Consultee Comments for Planning Application 21/00840/ADFULL

Application Number: 21/00840/ADFULL

Address: Ground Floor Lords Cricket Ground St John's Wood Road London NW8 8QN

Proposal: Details of details of the ventilation system to get rid of cooking smells pursuant to Condition 28 of planning permission dated 29 March 2019 (RN: 18/08510/FULL).

Dimension from Compton Stand Kitchen Horizontal discharge duct and Ground Level.

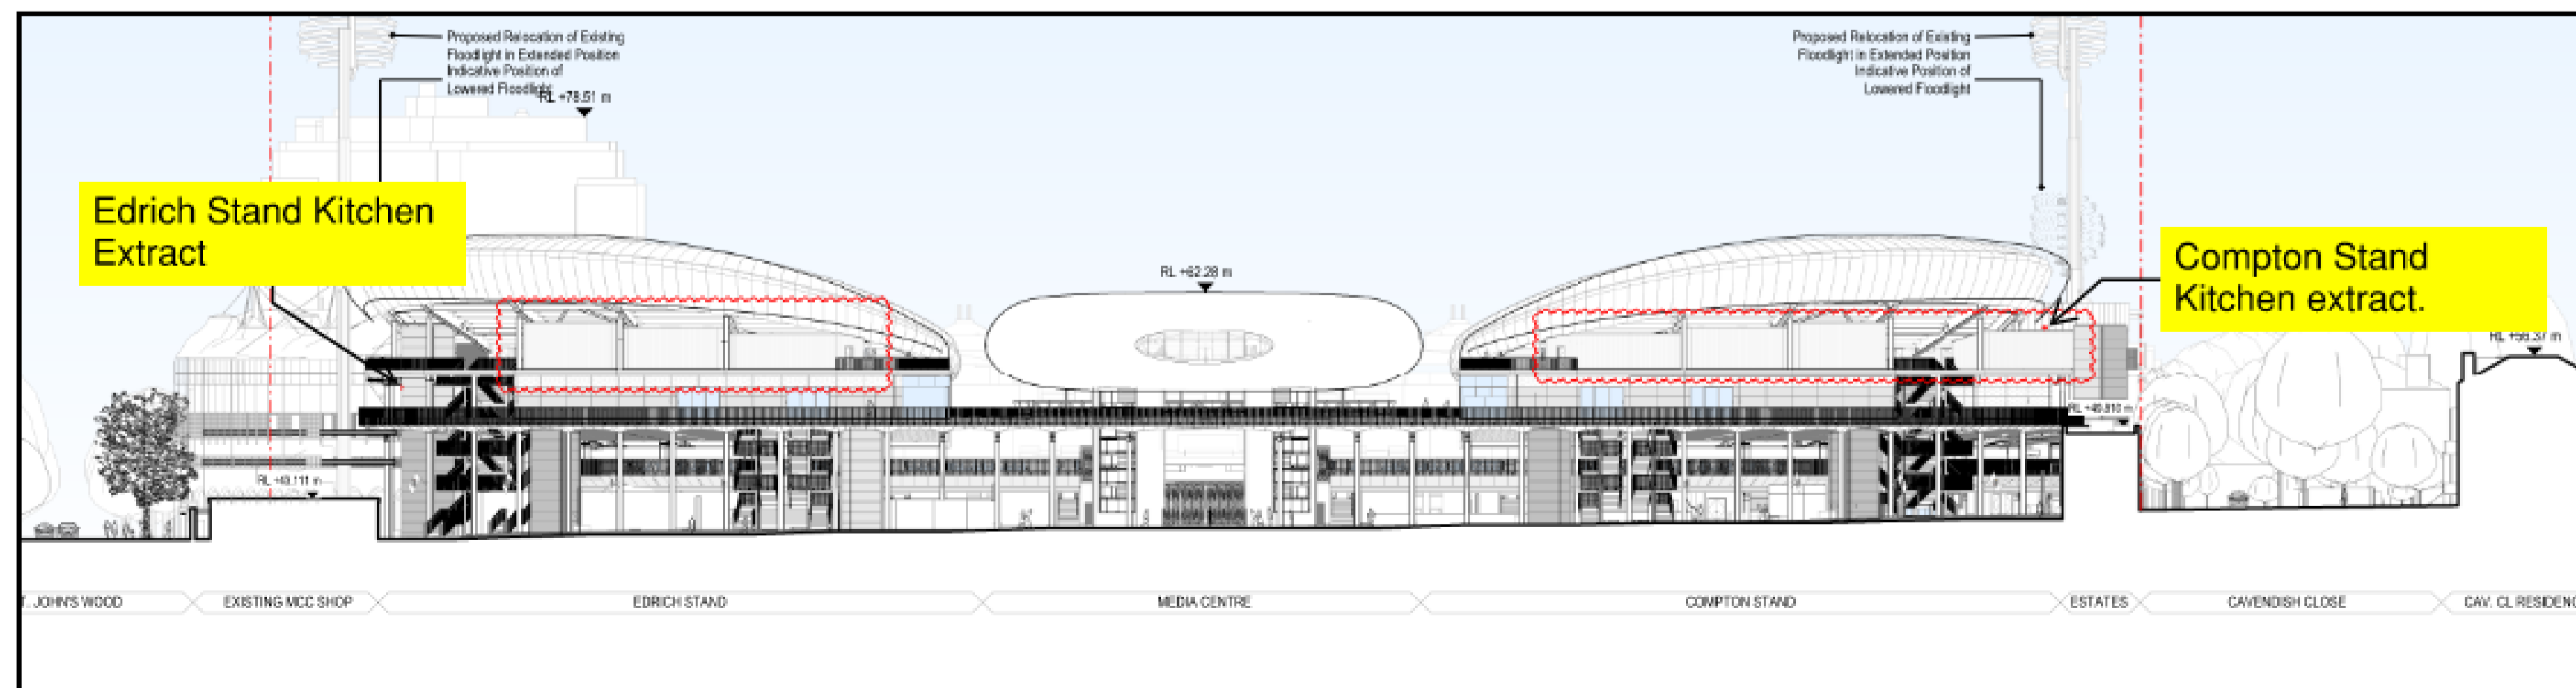
The application does not demonstrate where the kitchen extract terminates relative to the height of other buildings in the area; namely off site receptors. The application would have to meet the councils kitchen extract guidance. We require plans demonstrating the termination point of the kitchen extract, how that relates to receptors, including the distance and also the height of the termination point of the kitchen extract relative to receptors.
